Submission No.			259	
Organisation Name or Name of Submitter			Prionsias Mac Fhlannchadha (6 Wilkins Court, Limekiln Lane)	
Item No.	Section Ref.	Page No.	Observation Statement	TII Response
Observation on a Stratgeic Infrastructure Development Application				
1	Observation details 5. Grounds	3	I wish to firstly state my full support for the Metro plan with the exception of the intention to extend to Charlemont.	Thank you for taking the time to make a submission and your overall endorsement of the MetroLink Project with the exception of extending MetroLink to Charlemont Station. We have reviewed your submission and responded to the observations made below.
2	Observation details 5. Grounds	3	As confirmed by the NTA, the Draft Greater Dublin Area Transport Strategy 2022-2040 was presented for Public Consultation in January with the report issued to the Minister in April. Under Section 12 of the Dublin Transport Authority Act, until such time as the Minister approves the Draft Plan for 2022-2040, the plan covering this development is the Greater Dublin Area Transport Strategy (2016-2035) (“the Plan”) and any reference to draft plans in this application is premature by the Applicant.	Th

TUNNEL ALIGNMENT
SAINT STEPHEN'S GREEN – CHARLEMONT
RO APPLICATION VS DEEPER VERTICAL ALIGNMENT OPTION

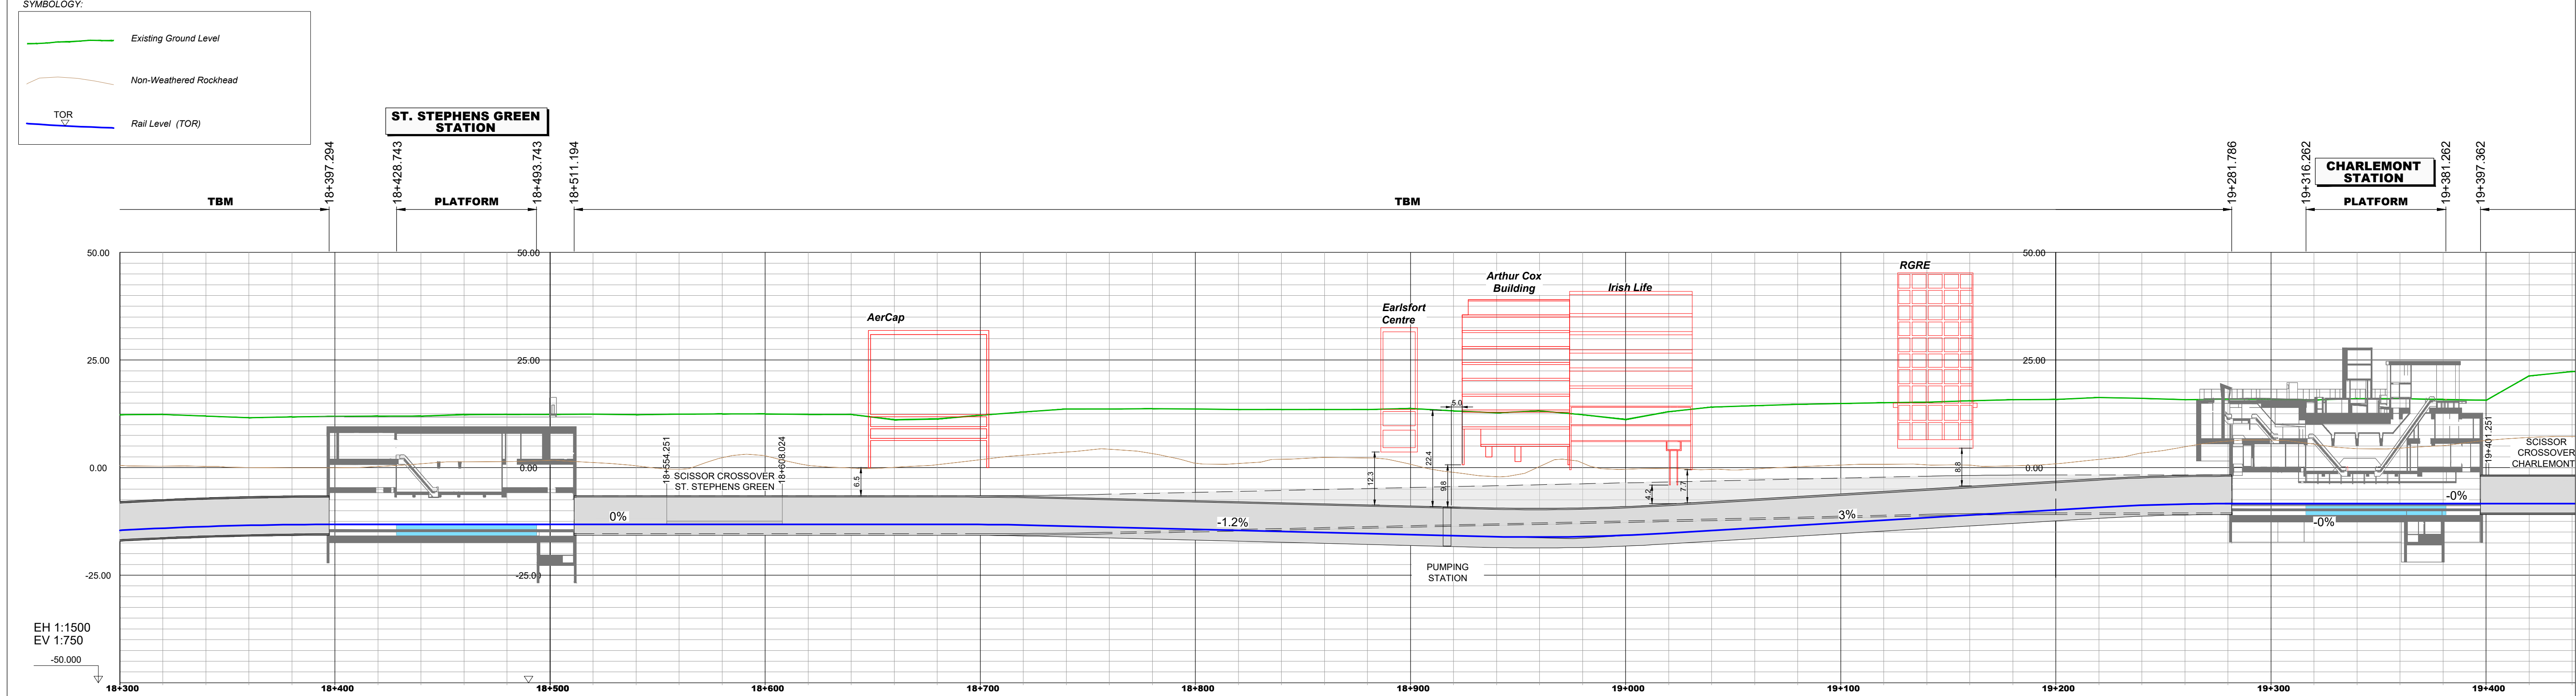
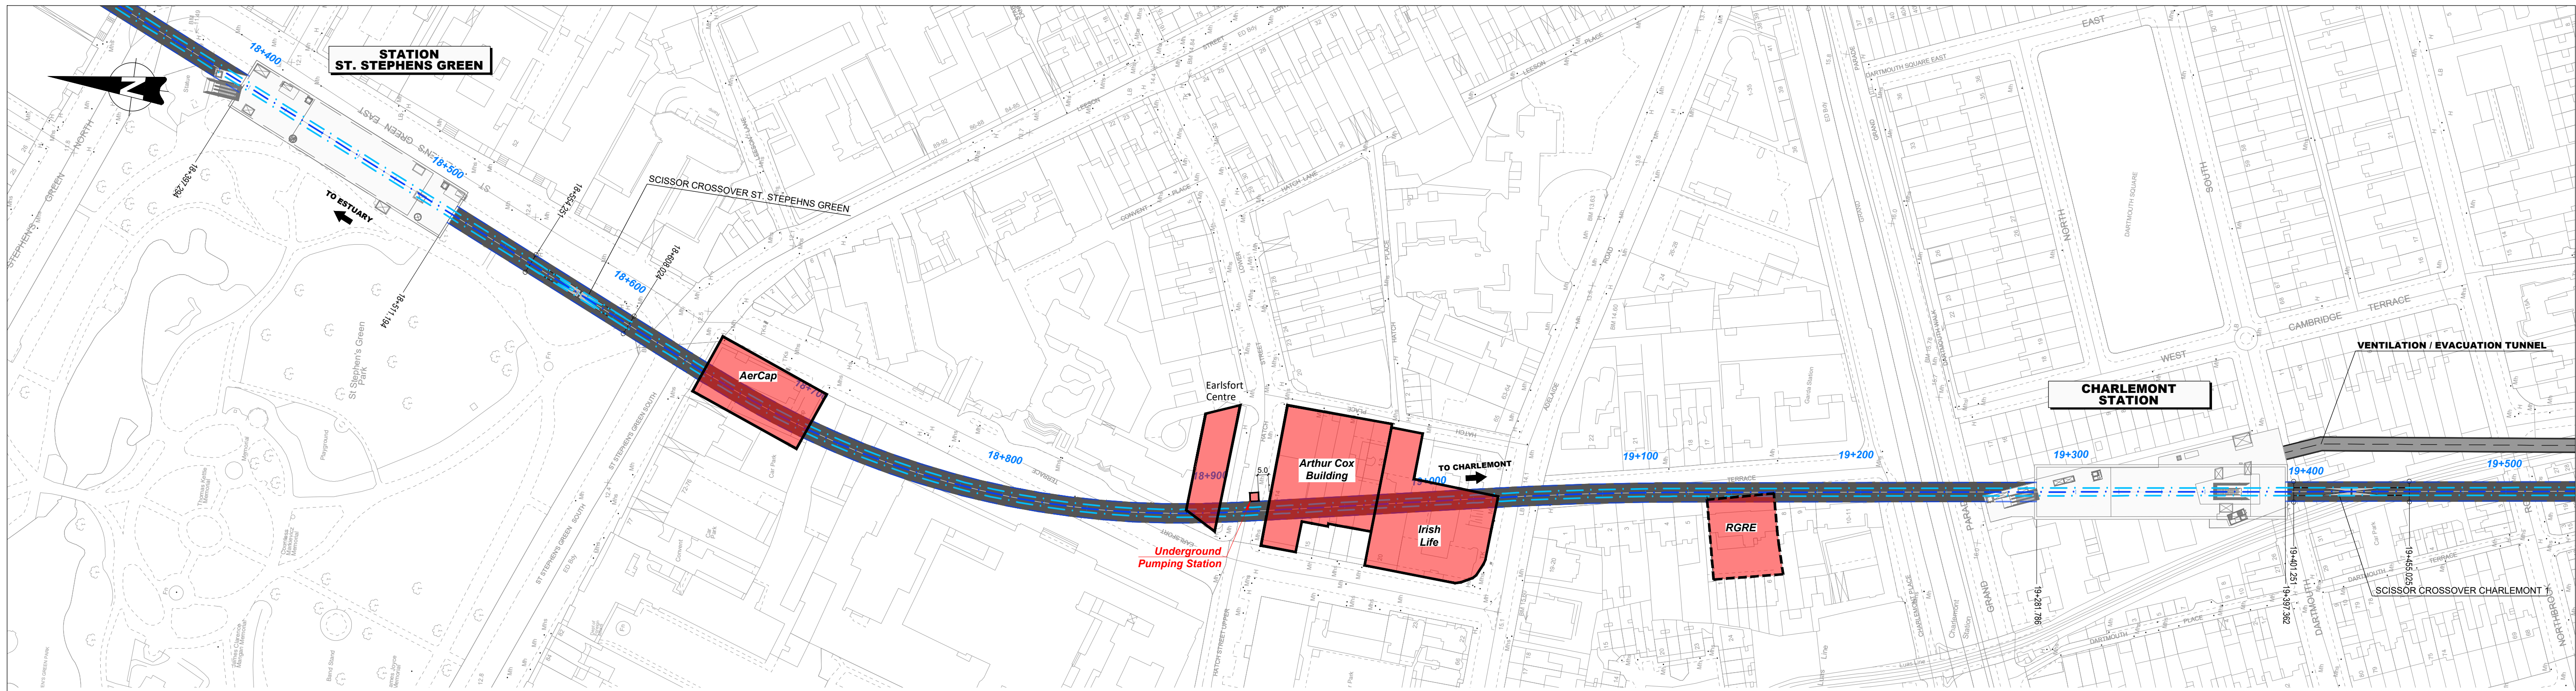
6	Observation details 5. Grounds	4	I hope that the Bord can consider approving this valuable scheme which will greatly help improve connectivity in the GDA but omit the extension of the Metro North to Charlemont due to the lack of support for an extension to same and the impact it may have on future extensions to the line.	The above responses to the observations made explain why TII do not consider it is correct or appropriate that the MetroLink alignment is not continued to Charlemont, and also explains why the proposed Charlemont Station has been selected by TII as the preferred interchange with the Luas Green Line A scheme that does not extend to Charlemont would not be consistent with the Transport Strategy for Greater Dublin Area (2022-2042), as approved by Cabinet. In addition any decision to terminate the scheme before Charlemont will significantly impact on the overall viability and benefits of scheme.

Response (4) continued.	<p>In summary, an alignment that links the proposed Tara, St Stephen’s Green East and Charlemont stations is a more direct and economic alignment, does not require additional intervention infrastructure, avoids a complex engineering interface with the Luas Green Line, impacts the Park less and has less potential for disruption during the construction phase.</p> <p>Response (3) above explains the reasons for why TII are proposing a station at Charlemont, noting that there is a limit to the potential of the Luas to provide additional capacity in the on-street non-segregated section of the Luas Green Line from Charlemont northwards through the city centre. The nature of this route and the fact that it currently crosses several road junctions (Adelaide Road, Harcourt Street / Hatch Street upper and Harcourt Street / St Stephen's Green south) limit the service to a maximum of 24 trams per hour per direction. The projected demand for this section would require a higher frequency of up to 30 trams per hour and this demand cannot be met with on-street systems (Luas / bus). The interchange between Luas and MetroLink proposed at Charlemont will provide the necessary capacity to address the demand on this corridor and reduce overall travel time for passengers</p> <p>There is also high passenger demand forecast for a Metrolink station at Charlemont, including from the Ranelagh area, which would be lost if St. Stephen's Green was the MetroLink southern interchange station. The additional fare revenues collected by the Charlemont Station interchange increase the benefits delivered by the Project, reflected by an improved Project Benefit Cost Ration (BCR). It is therefore not justifiable to propose that this section of the proposed line is "value engineered out" given the benefits it will deliver.</p> <p>Finally, while JASPERS comments are noted, it is also of note that in July 2022, the Government granted Approval in Principle to the NTA to enable the submission of a railway order application by TII to An Bord Pleanála in respect of the MetroLink project (Decision Gate 1). This approval was granted after the Preliminary Business Case (PBC) had undergone significant scrutiny and challenge by bodies that are independent of TII, including DoT and DPER review (including independent review by JASPERS and the Major Projects Advisory Group (MPAG)) of the PBC around timeline, costs and benefits that were updated to inform the Government decision.</p>
